OBJECTION

State Significant Development Application No: SSD-10300
Coffs Harbour Cultural and Civic Space

GORDON ST ELEVATION

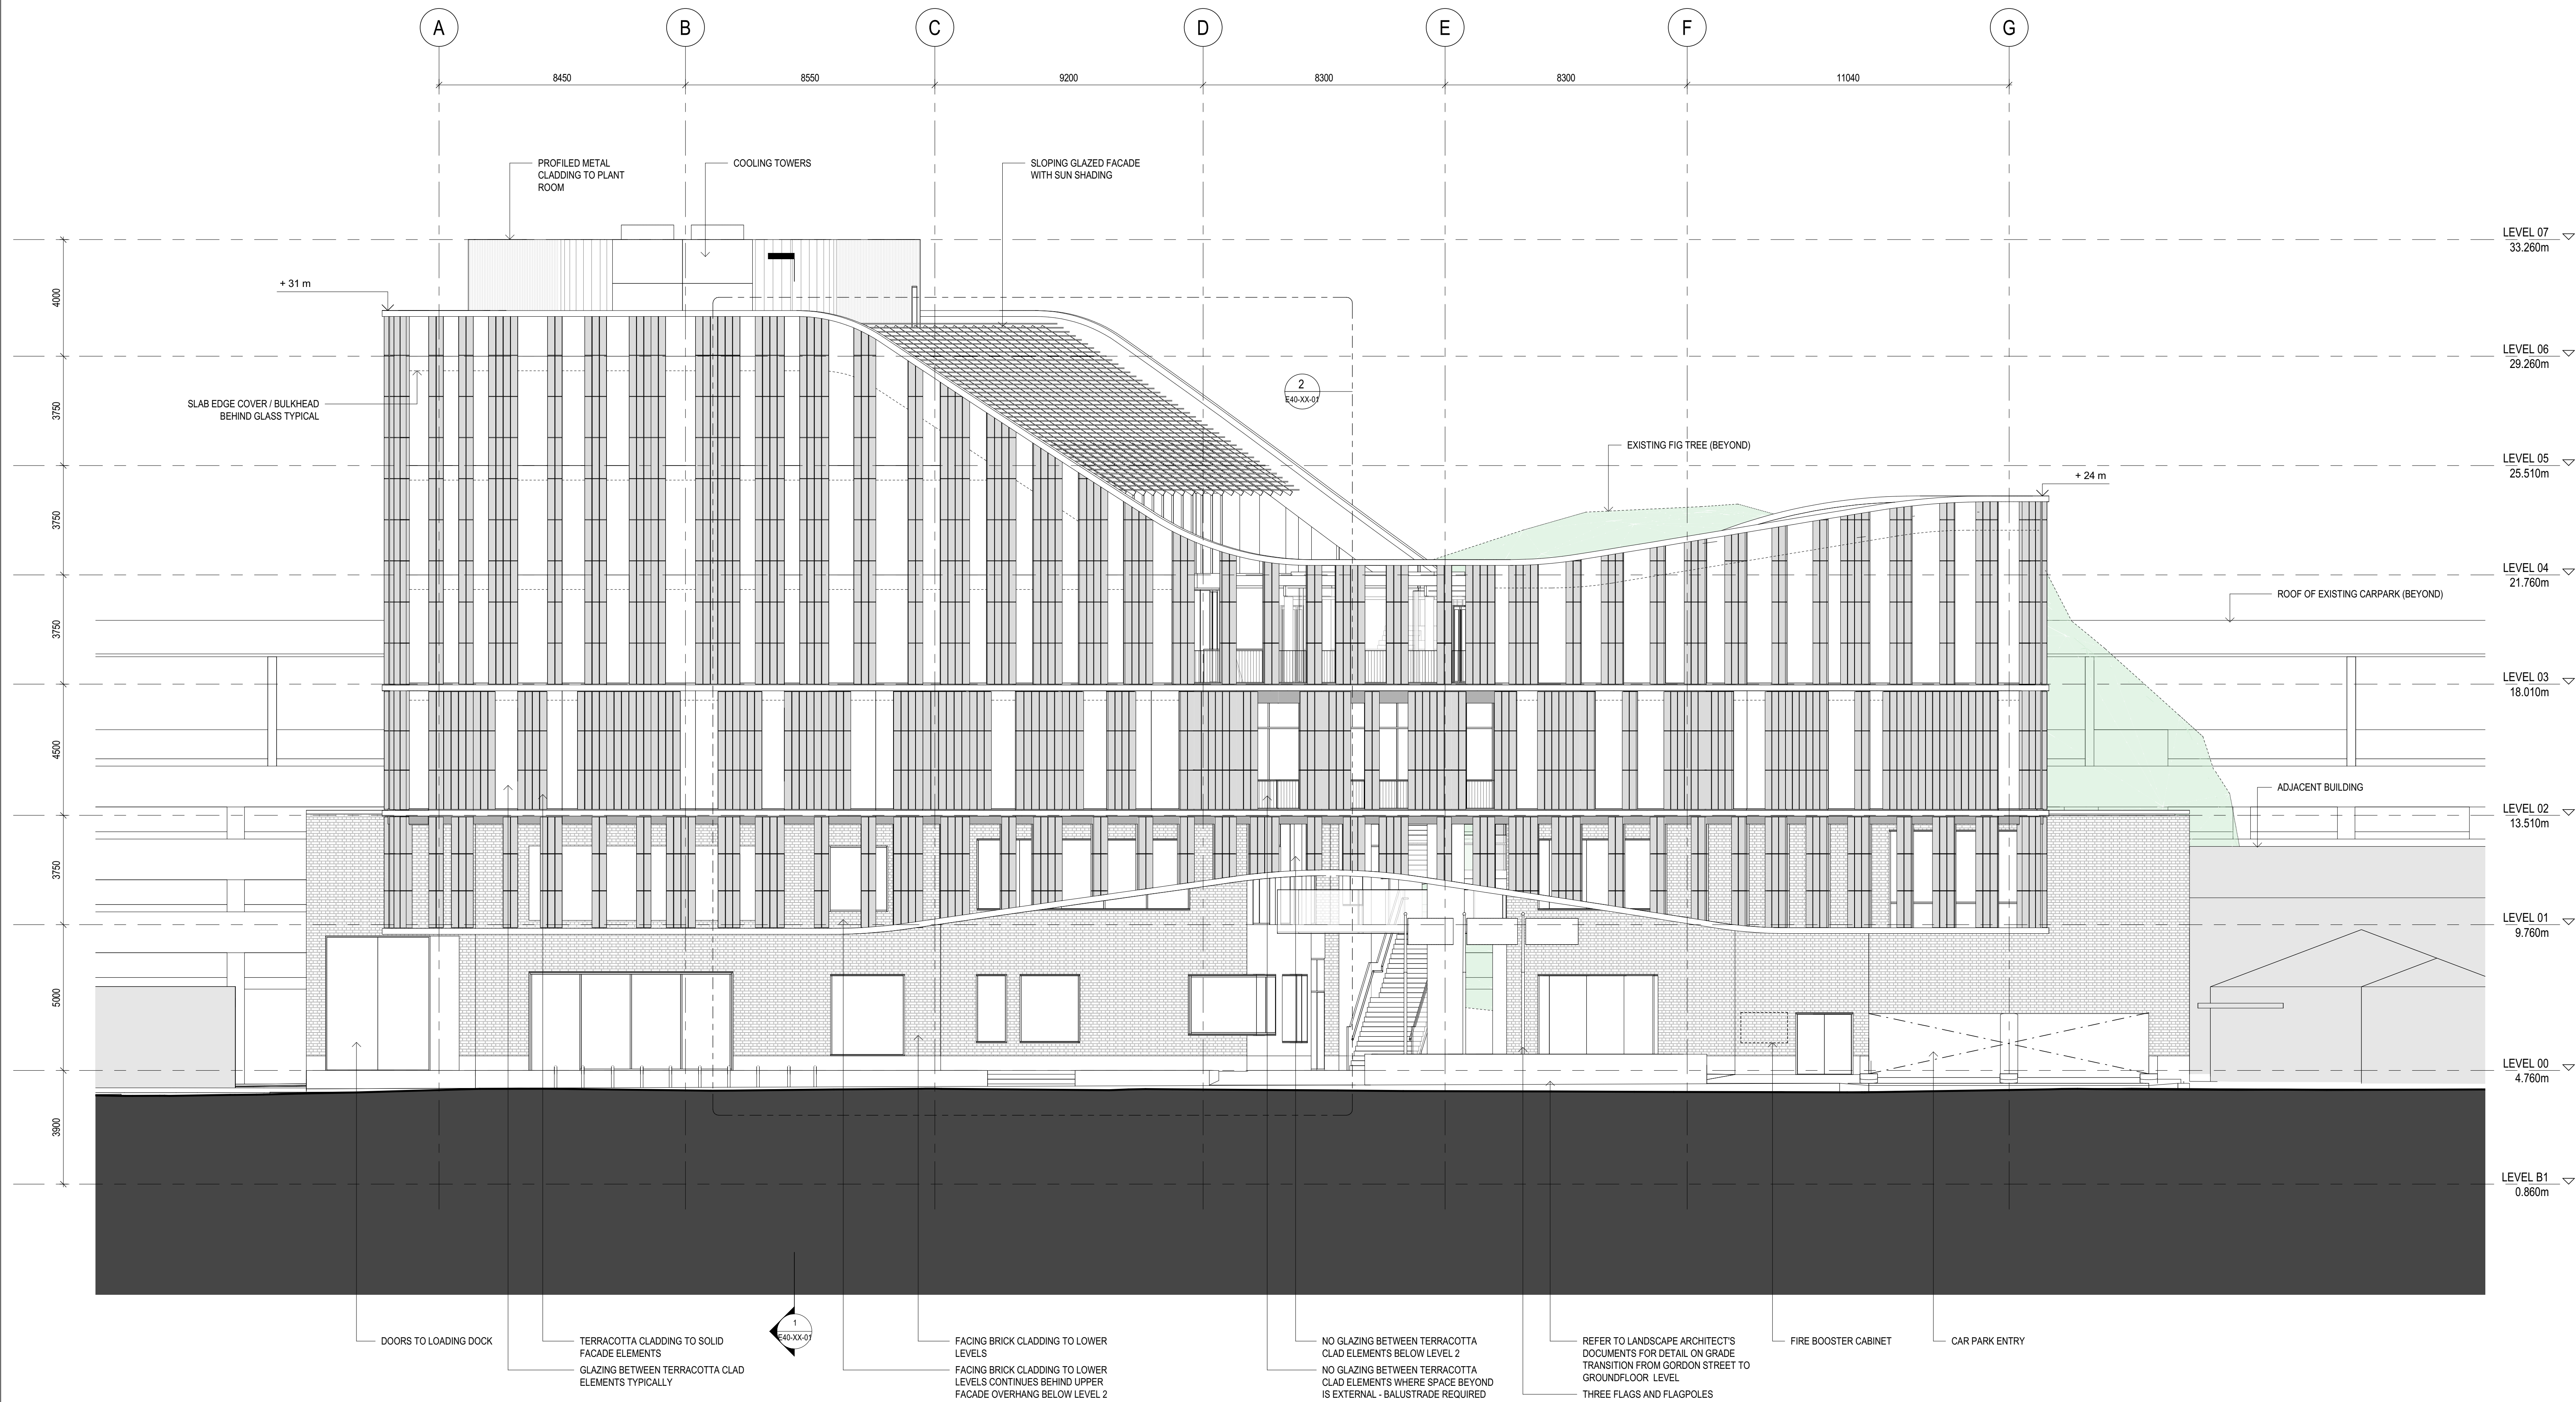
5. The proposed building is out of context in the street with no regard to scale, existing street setbacks, design and general form of adjoining buildings.
